Our ref: DOC22/761565

Your Ref: SSD-33258337

Thomas Piovesan
Senior Planning Officer
Key Sites Assessment
Department of Planning and Environment
Locked Bag 5022
PARRAMATTA NSW 2124
23 September 2022

Subject: Request for Advice: TOGA Central (SSD-33258337)

Figure C2
PMF Developed
Depth and Elevation

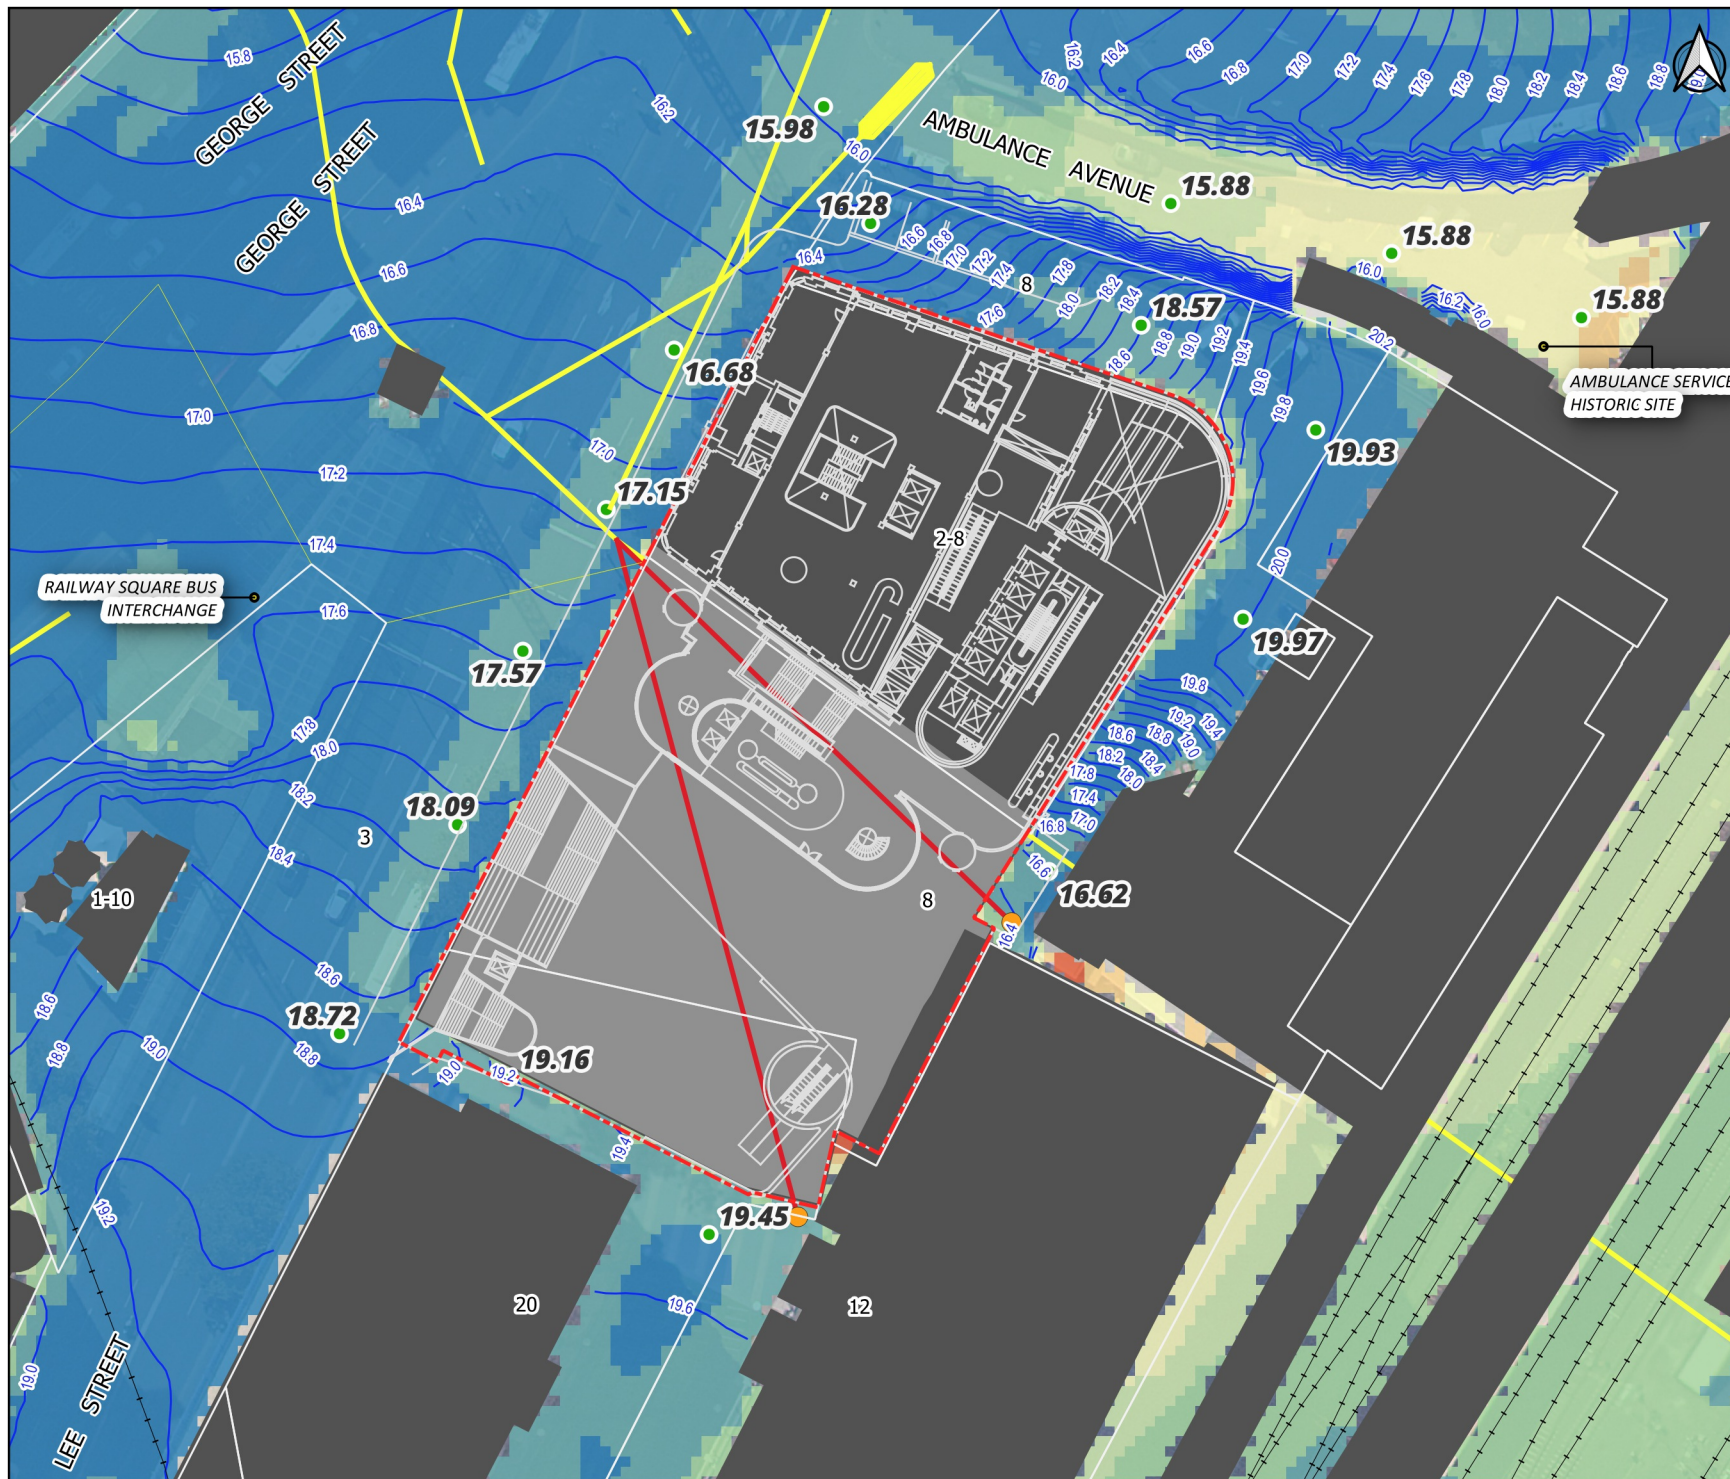
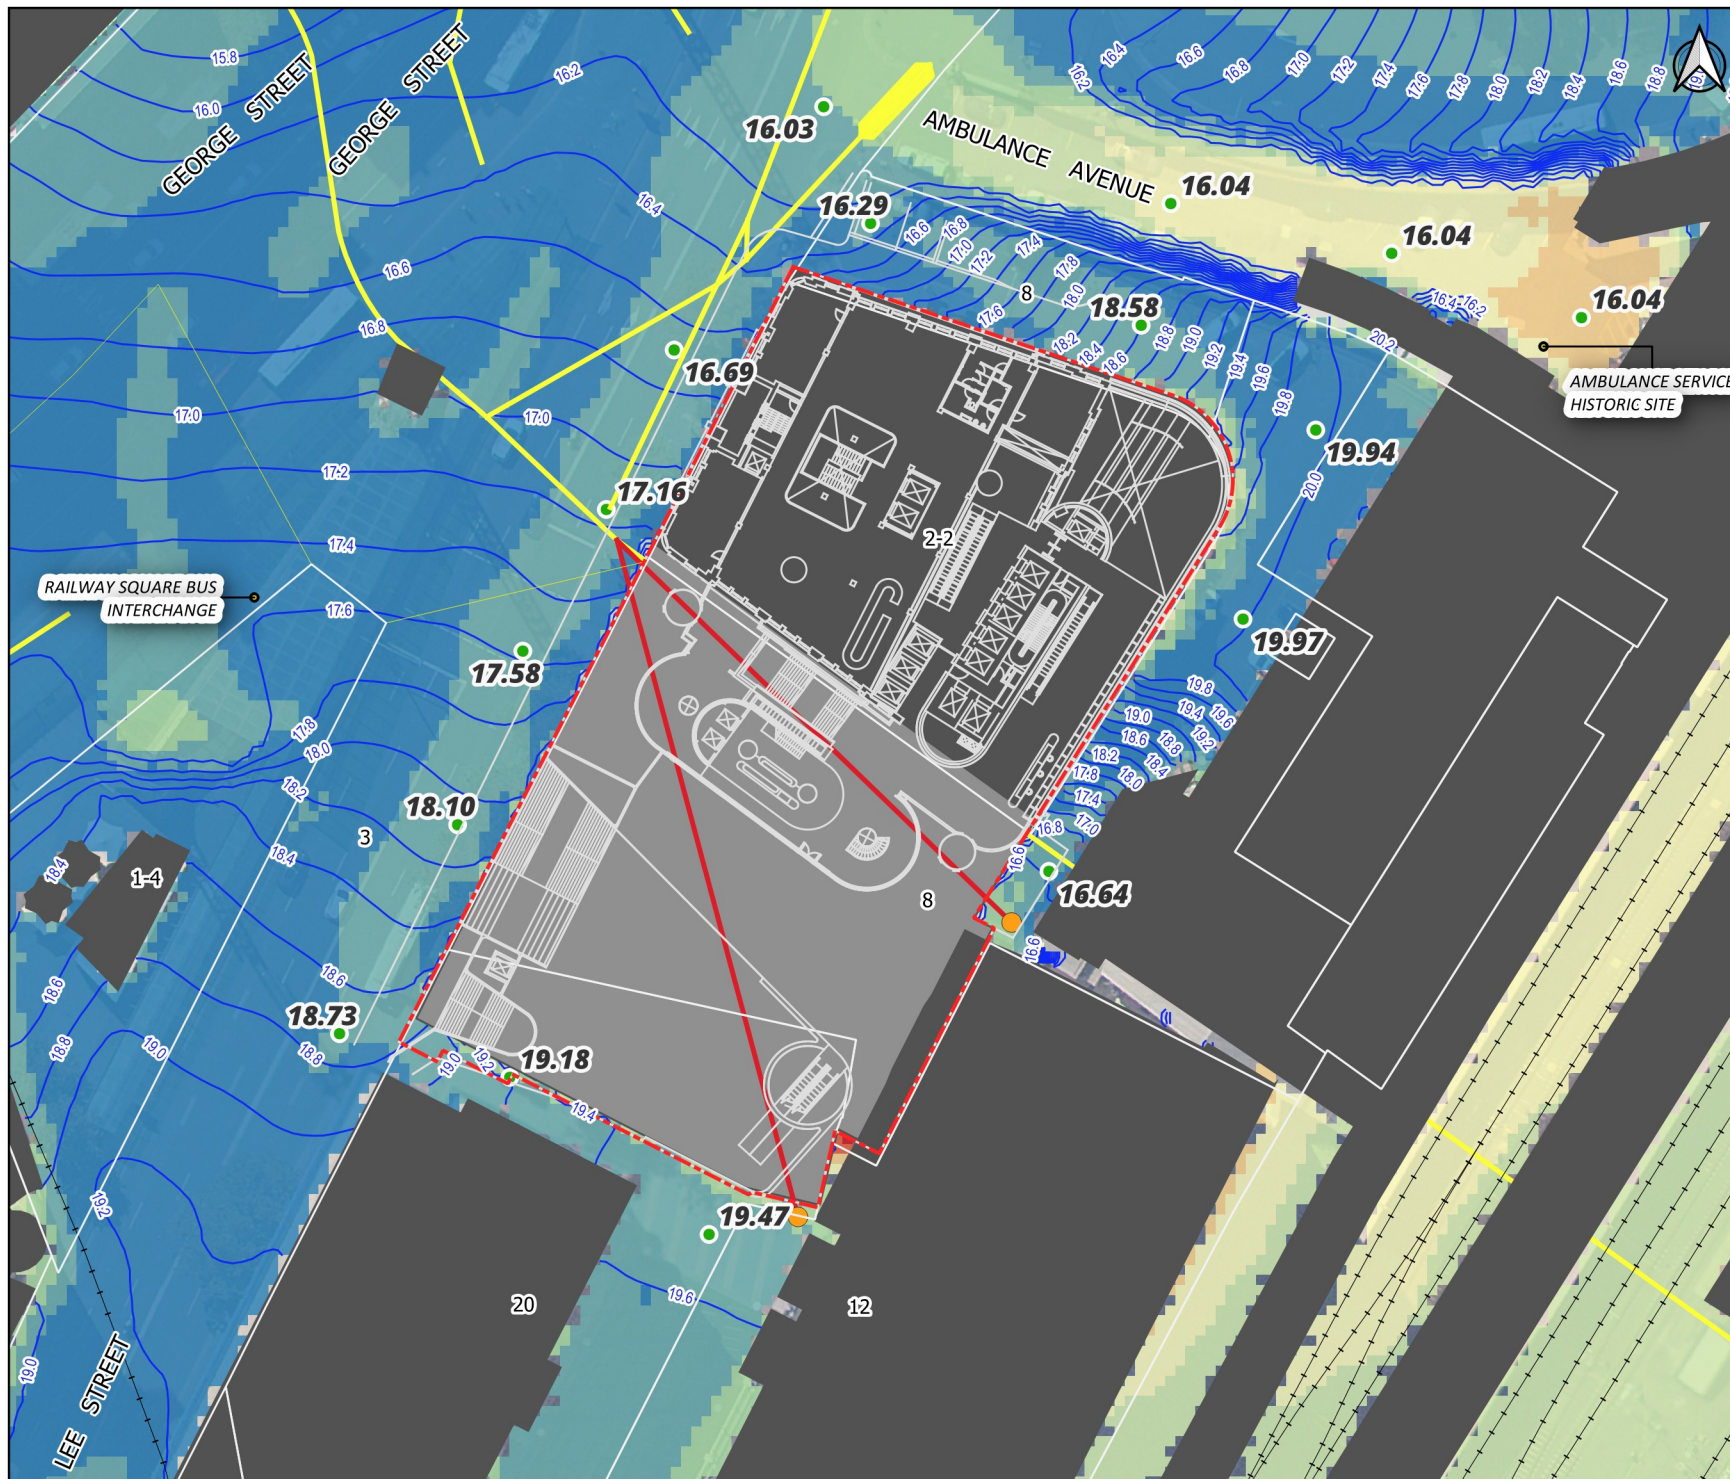
EHG has reviewed the flood assessment and recognises that the proposed development appears to remove floodplain storage from Henry Deane Plaza. The proposed development would also include connecting local stormwater into the Sydney Water pipe. These changes may worsen flooding downstream, and the assessment should be updated to include flood impact maps to demonstrate the potential downstream impact.
